October 30, 2014

Re: 131 New Island Avenue, Peaks Island – 085-G-003 – IR-2 Island Residential Zone – Permit #2014-02458 – unpermitted deck

X2 Overhead of Deck

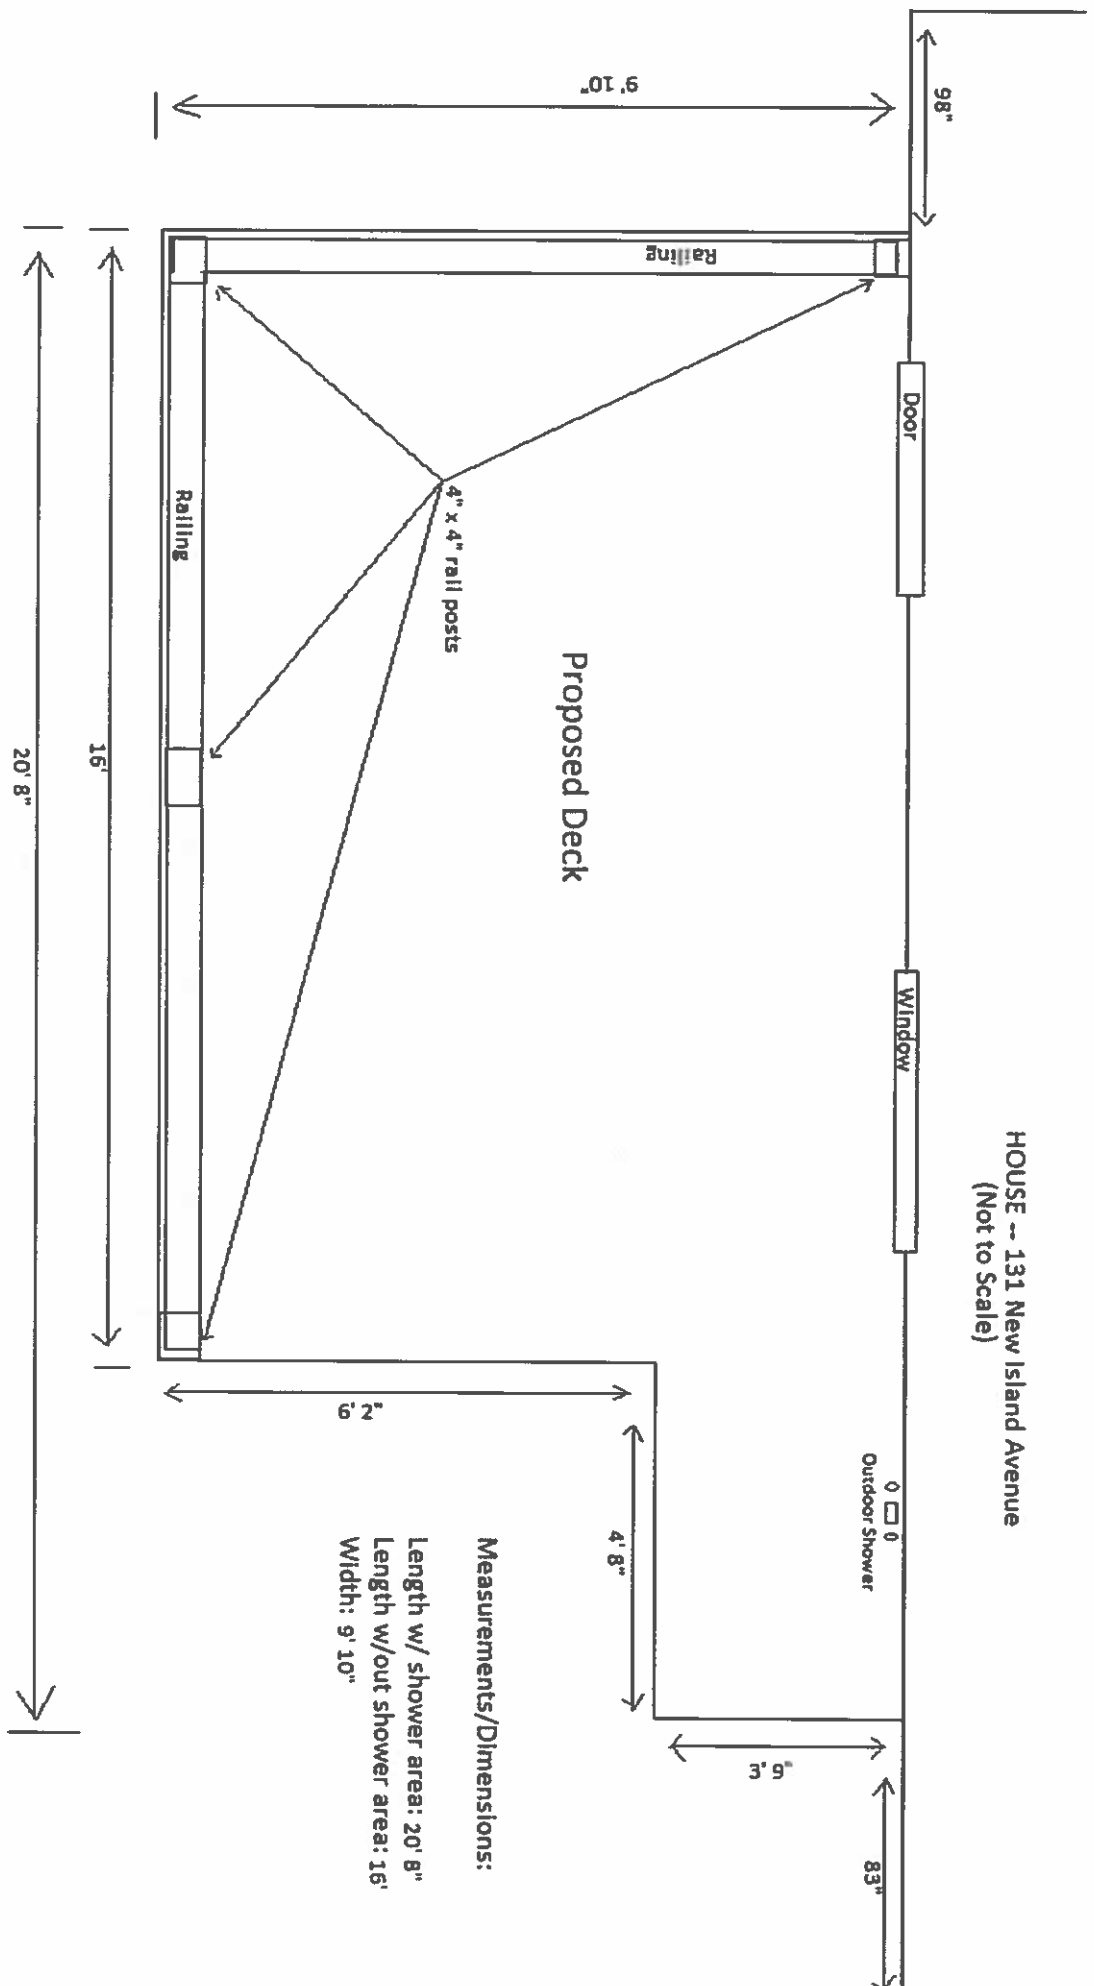
I have reviewed your application to permit the 9'10" by 16' deck and 3'9" by 4'8" shower area that was built at your property without a building permit. I am denying your permit because the structure does not meet the setback and lot coverage requirements.

131 New Island Avenue, Peaks Island is located in the IR-2 Island Residential Zone. Section 14- 145.11(c) spells out the minimum required setbacks. The minimum required front setback is twenty-five feet, and the minimum required rear setback is twenty-five feet. The plot plan that was provided with the permit appears to have given the front and rear setbacks from the edge of the streets and not from the property lines. Where the proposed deck sits on the lot, the lot is only fifty feet deep. The deck is 20'8" long. If you subtract that from 50', the difference is 29'4". The 25' front and rear setbacks cannot be met.

Section 14-145.11(d) states that the maximum lot coverage is twenty percent of the lot. The lot is 5,550 square feet. The footprint of the existing structure is 1,116 square feet. The deck and shower area is adding 174.8 square feet. The new footprint would be 1290.8 square feet which covers 23.3% of the lot. This exceeds the allowable lot coverage of twenty percent.

You need to bring your property into compliance. Since the deck and shower area does not meet the required setbacks or allowable lot coverage, it cannot be permitted and it needs to be removed. You have thirty days to remove the deck.
